# CITY OF ALBUQUERQUE

**RE: Alvarado Roofing  
4015 Hawkins St. NE  
Grading and Drainage Plan  
Engineer's Stamp Date: 02/20/20  
Hydrology File: D17D008**

Based upon the information provided in your submittal received 03/10/2020, the Grading & Drainage Plan **is not** approved for Building Permit, SO-19 Permit, and for action by the DRB on Preliminary Plat. The following comments need to be addressed for approval of the above referenced project:

GRADING & DRAINAGE PLAN

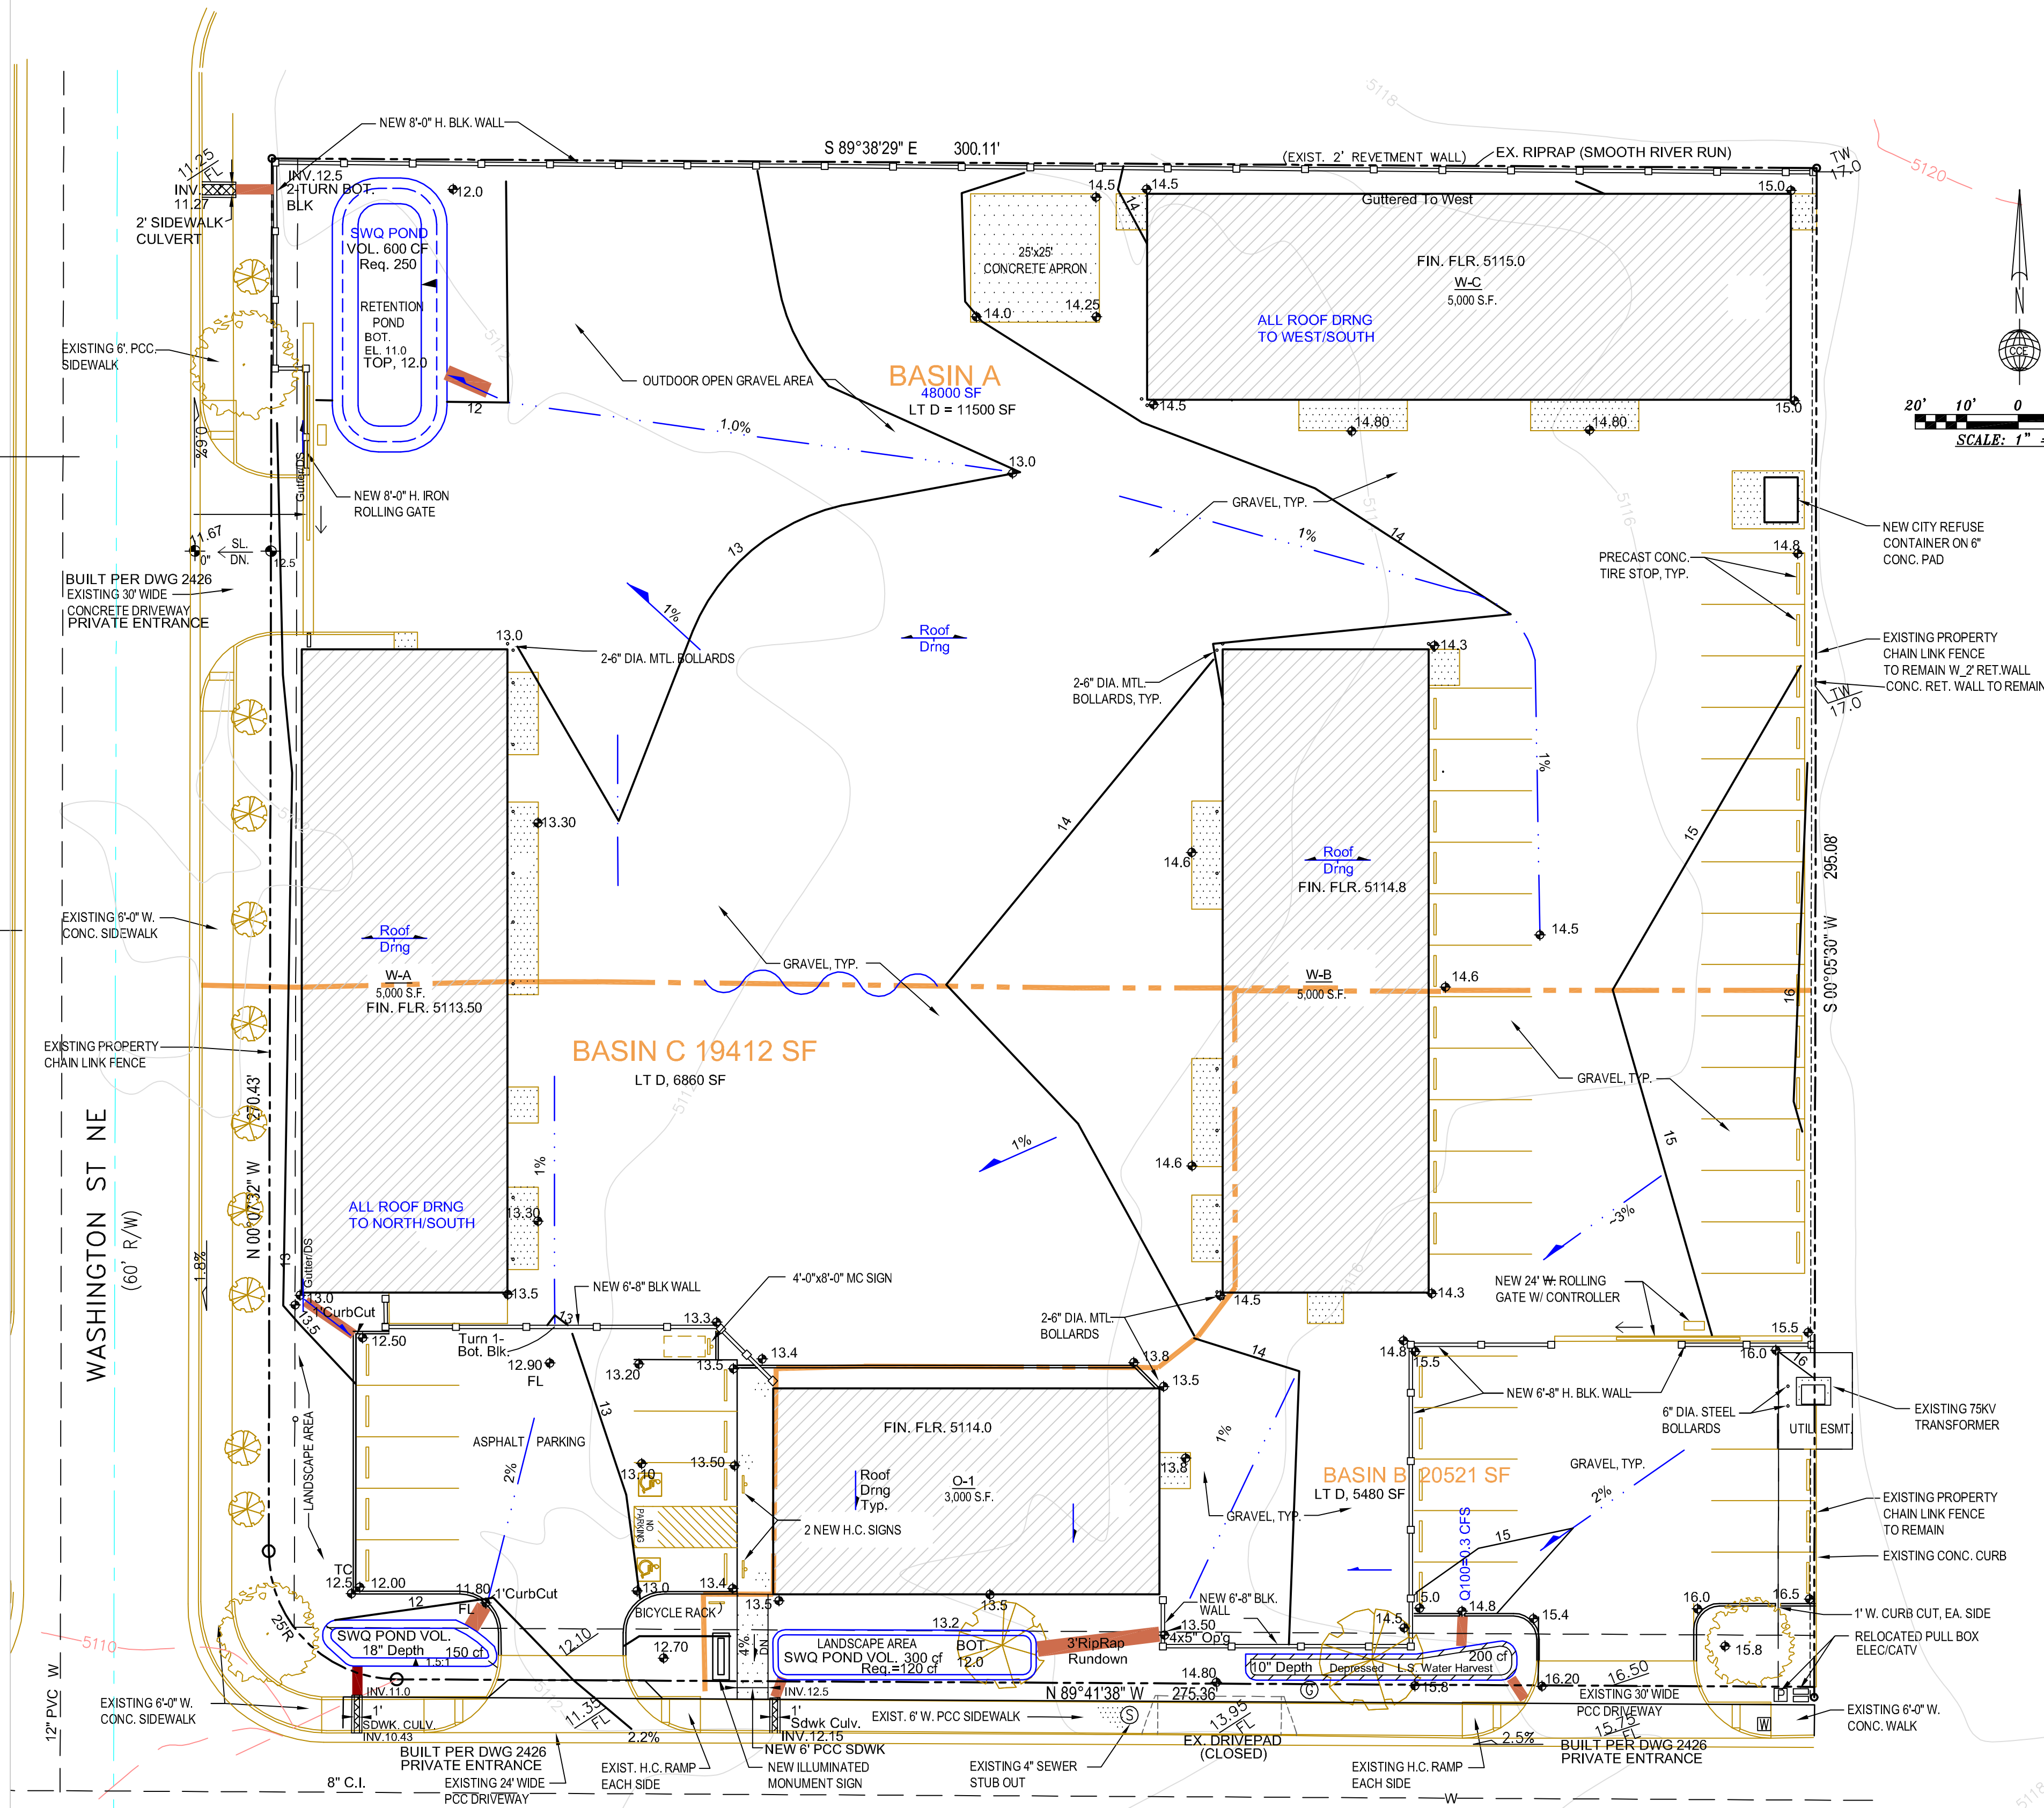
1. Please use the drafting standards outlined in the DPM. Plans need to be black & white with appropriate line weights for existing and proposed items. Color plans are very hard to read.

2. Please provide the FIRM Map and floodplain note with effective date.
3. Under Existing Conditions, please correct the last statement ... "Volume 100 = 8203 CF [XXX]". What is the [XXX]?

4. Please make the storm water quality (SWQ) volume calculation a more clearly readable. Please also state the total provided storm water quality volume for the site.

5. For the sidewalk culverts, instead of the orifice equation which was used, the broad crest weir equation (equation 6.60 in the DPM) must be used, not the orifice equation. A coefficient of 2.7 is typically used for the equation  $Q = CLH^{2/3}$ .

6. Please reference City of Albuquerque standard detail No. 2236 – Sidewalk Culvert with Steel Plate Top at the sidewalk culvert.
7. Please update the SO-19 Permit Notes. See Attachment.

8. Please provide the proposed grades or existing grades on both sides of the proposed retaining walls and provide the top of wall elevation as well.
9. Please provide cross sections of the retaining walls along each property line. These sections should include the property line, the footer of the retaining wall, the distance between the property line and the wall, and any other pertinent information.

10. Per DPM Ch. 22.5.B, grading and construction of retaining walls at or near the property line must demonstrate that the adjacent property is not damaged or its use constrained. Any such encroachment by the wall or grading must be accompanied by written permission of both landowners. Also any such encroachment by the wall within the City's R.O.W. must be accompanied by a licensing agreement.
